From: Simon Davis
Sent: 03 February 2021 12:37
To: Planning Scanning
Subject: FW: BR/8/21/RES

Application Correspondence "Request to make changes re EH objection"

From: Simon Davis
Sent: 03 February 2021 12:36
To: [REDACTED]
Subject: BR/8/21/RES

Drawing Title:
PROPOSED FLOOR PLANS

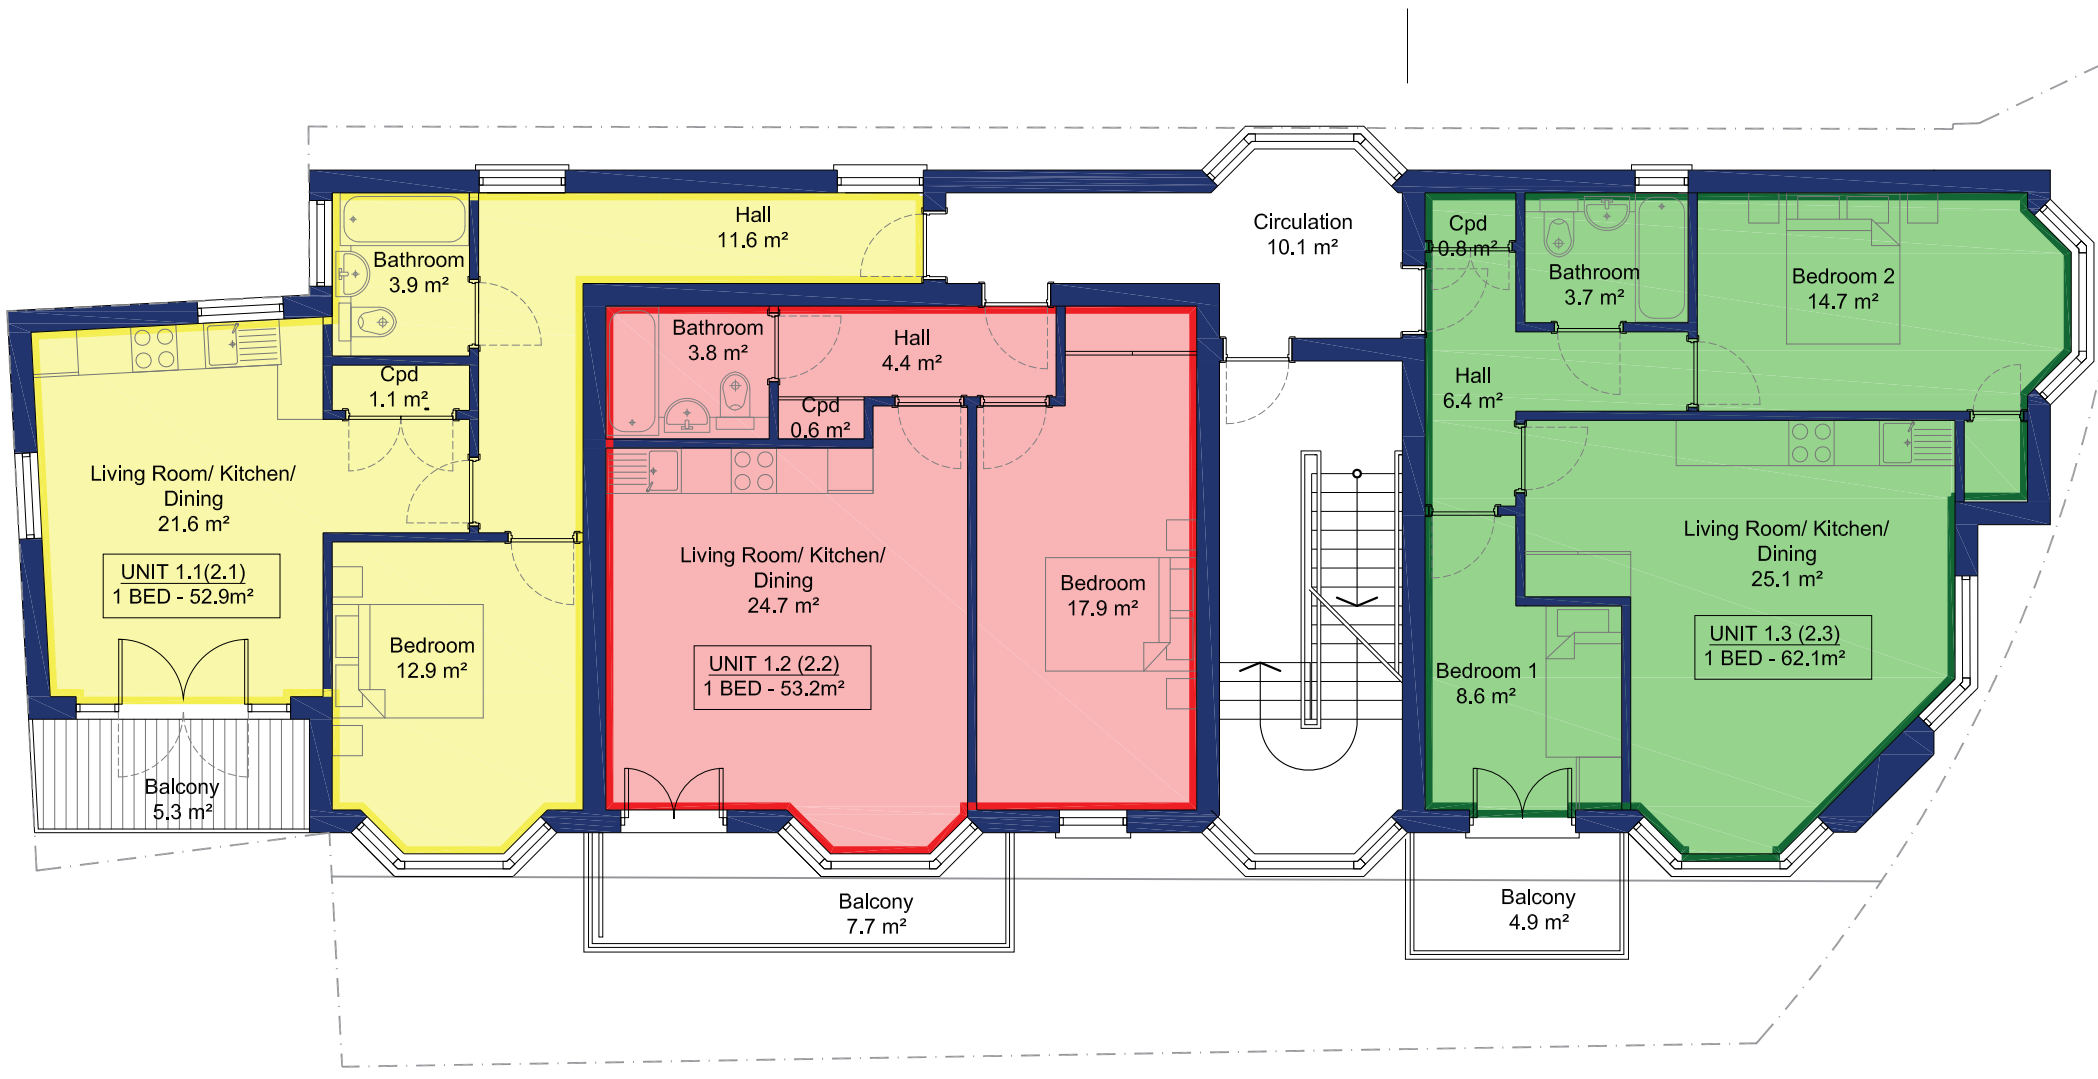
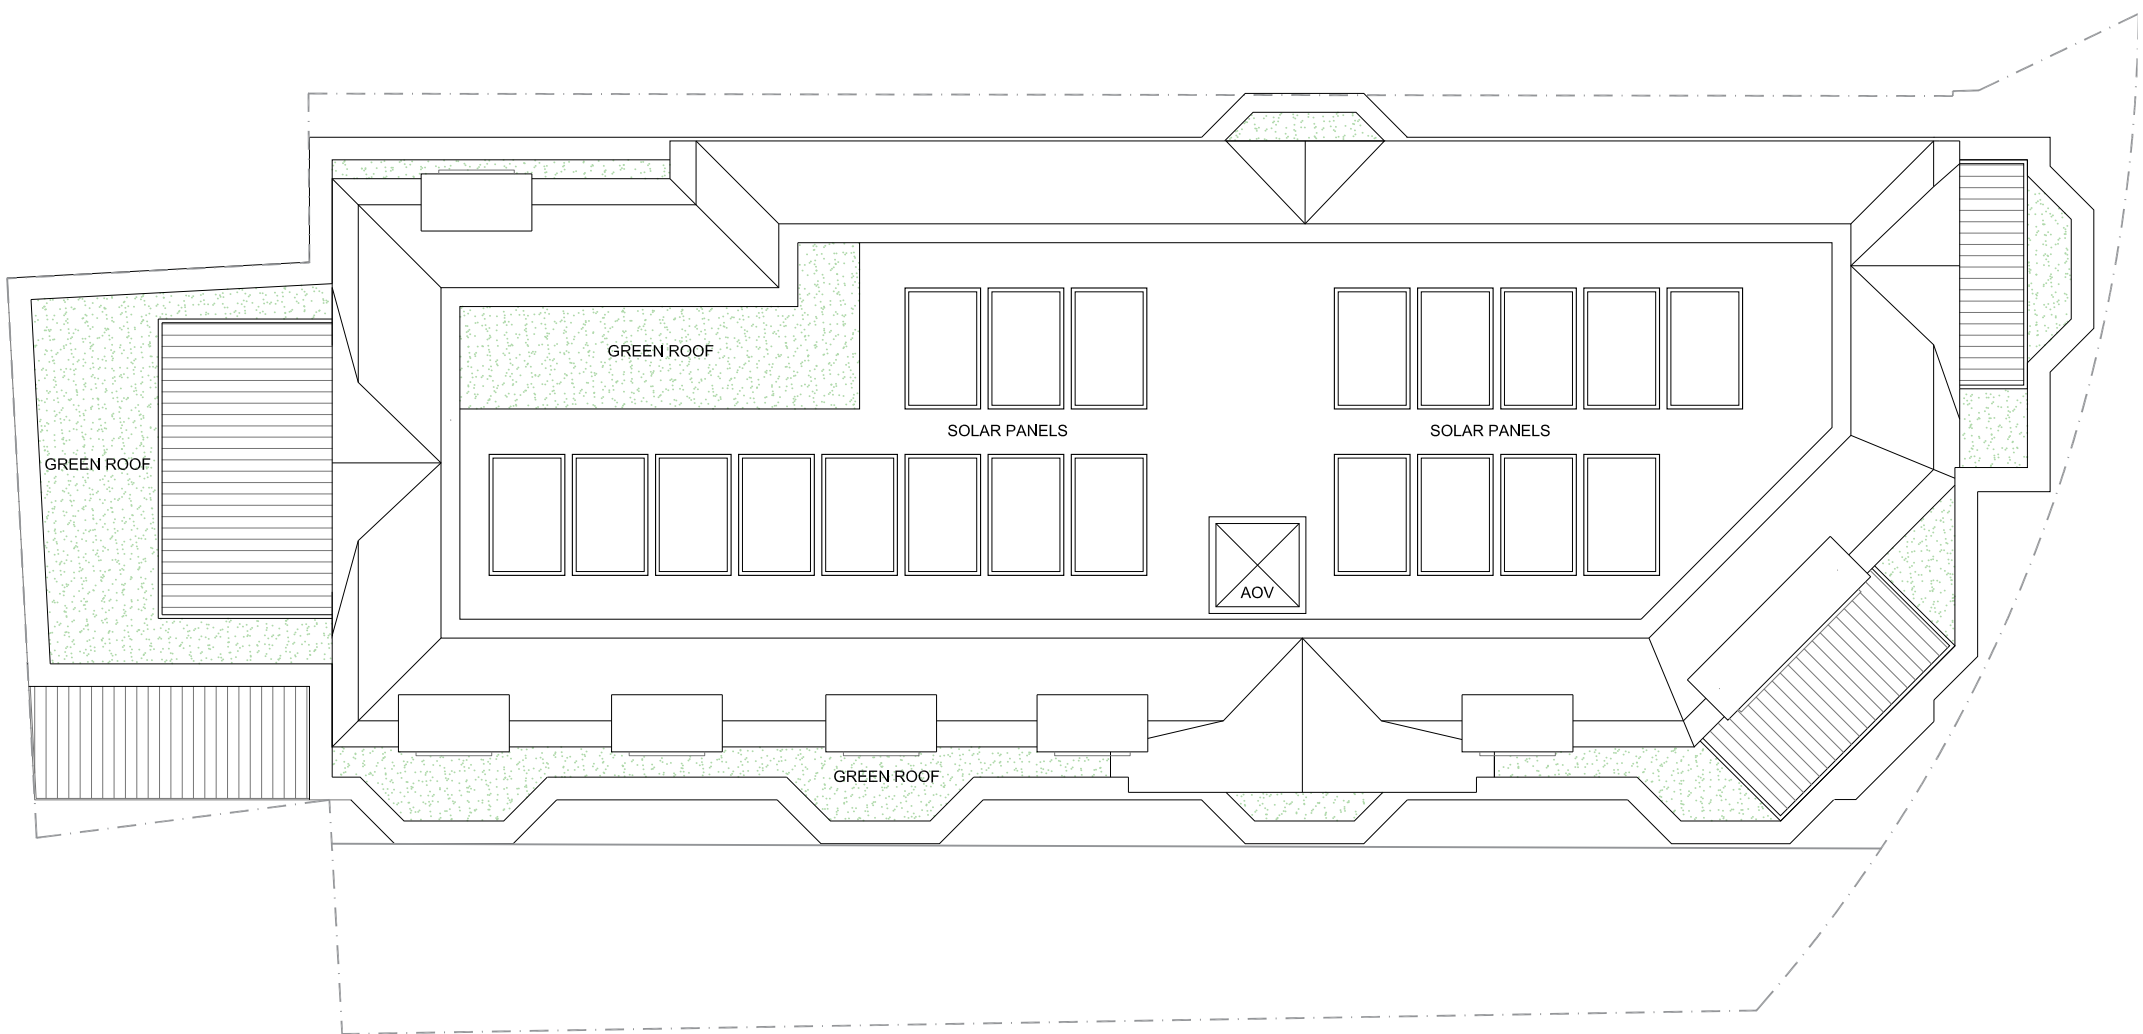
With reference to Environmental Health's comments on the original application (BR/142/18/OUT), Environmental Health objects to this application as the layout has habitable rooms facing the railway which will mean that BS8233 will only be met if the windows are kept closed. This application therefore does not follow the principles of good acoustic design within ProPG.

Please note that this was raised at the outline stage and indeed formed part of an informative 12 on the decision notice. I therefore write to request that you amend the floor plans/building layout to remove habitable rooms from the elevation backing onto the railway line. Please provide amended plans by the 17th February or if you need longer, advise me when you need until.
